**Recommendation Report for Works to Tree(s) on trees subject to a Tree Preservation Order (**

**REF NO:** FP/140/13/T

**LOCATION:** 29 Links Avenue  
Felpham

**PROPOSAL:** T1 Common Lime - re-pollard at 6 metres above ground level, removing 9 meters of crown above the pollard level; and T2 Common Lime-reduce crown by 5 metres.

T1 - SMALL-LEAFED LIME  
- RE-POLLARD

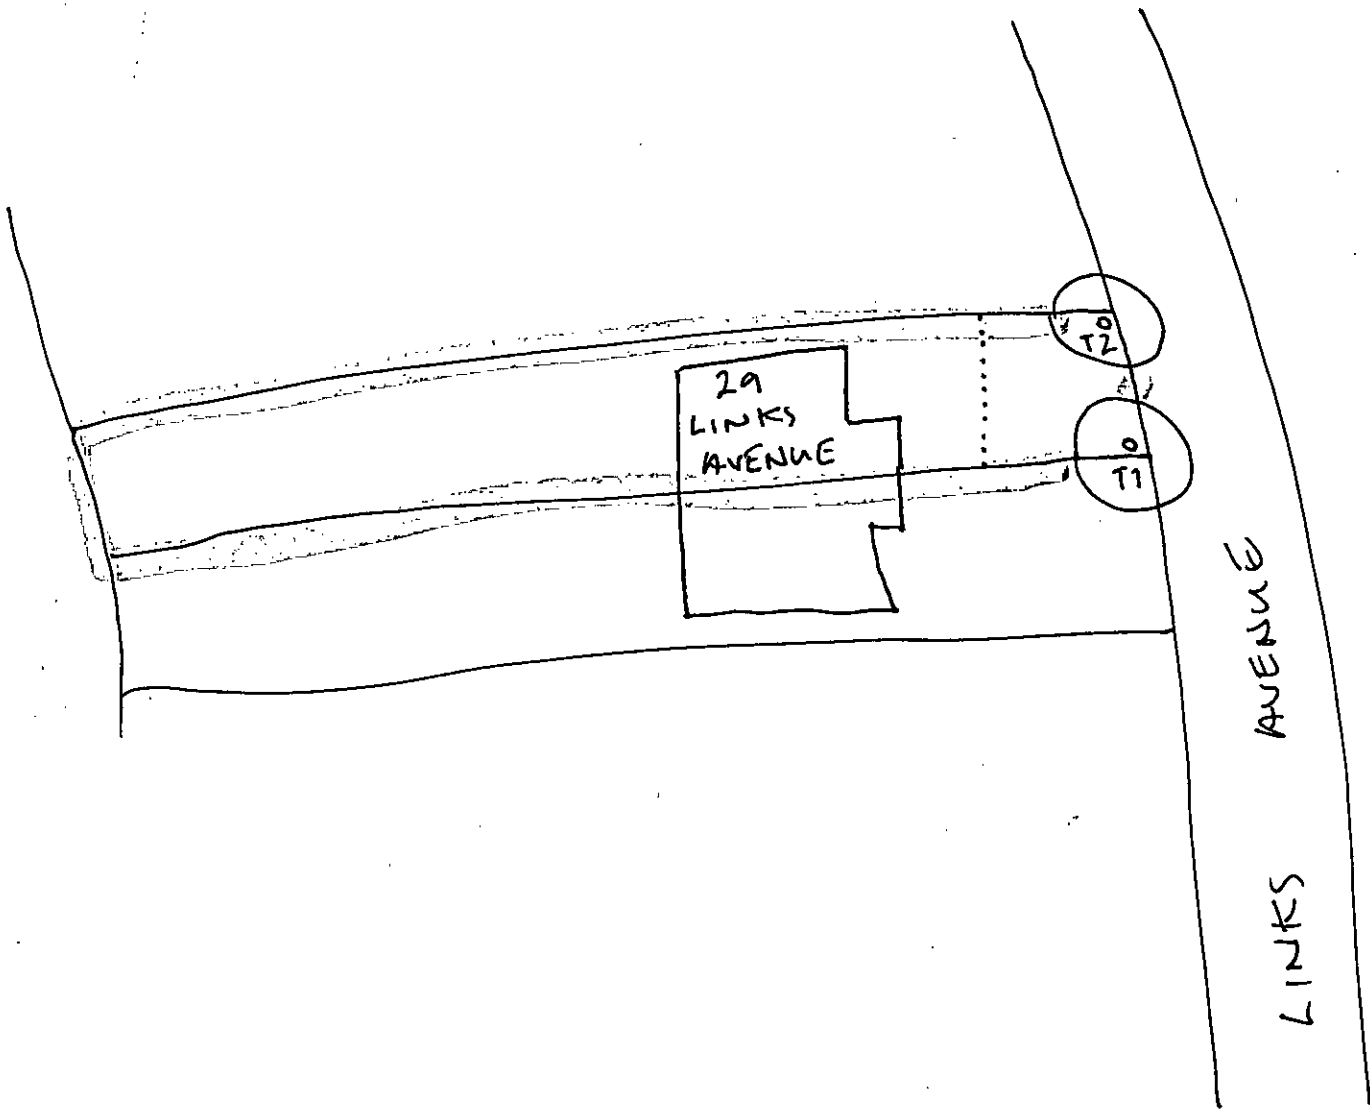
"The two Lime trees grow together and provide a good visual amenity in the street scene and their loss would be noticeable. I did not detect the presence of fungi at either tree's basal areas. However there was evident a juvenile developing Ganoderma fungi bracket. This is a parasitic organism and will destroy live supportive wood tissues. The fungi is emerging below the heavily decaying cavity of the main branching stem located at 3m from the ground of (T1) the Small Leaf Lime tree. This is a concern as it increases the likelihood of stem failure within a shorter period of time. The recommendation to reduce the tree to a 6m standing main stem height in accordance with the consultant's report is therefore acceptable.

The loss of T1's crown would expose the unevenness of T2 the Common Lime. Although there is a need to carrying formative pruning to T2, the cutting down to a similar height of a 6m high main stem is not recommended. It is preferably to retain the presence of tree height by recommending reduction of the crown by 5m to stimulate the production of an even and balance crown from an otherwise asymmetric shape. Recommend: T1 as per tree consultant's recommendations cut to leave main stem height of 6m; and T2 Reduce Crown by 5m, this should be carried out mainly from the North West with little to be pruned adjacent to T1. Wound sizes to be kept small restricting their diameter to 150mm or less. The tree work to T1 is necessary to abate a danger where a 5 days' notice to carry out the work is acceptable. If the crown reduction of T2 is unacceptable then the application for this work should be refused consent."

- 3 The works hereby approved shall involve: (A) T1: As per the Tree Consultant's recommendations namely cut to leave a main stem height of 6m; and (B) T2: Reduce Crown by 5m, this should be carried out mainly from the North West with little to be pruned adjacent to T1. All wound sizes to be kept small restricting their diameter to 150mm or less. All works shall be carried out in accordance with BS3998:2010 "Recommendations for Tree Work".
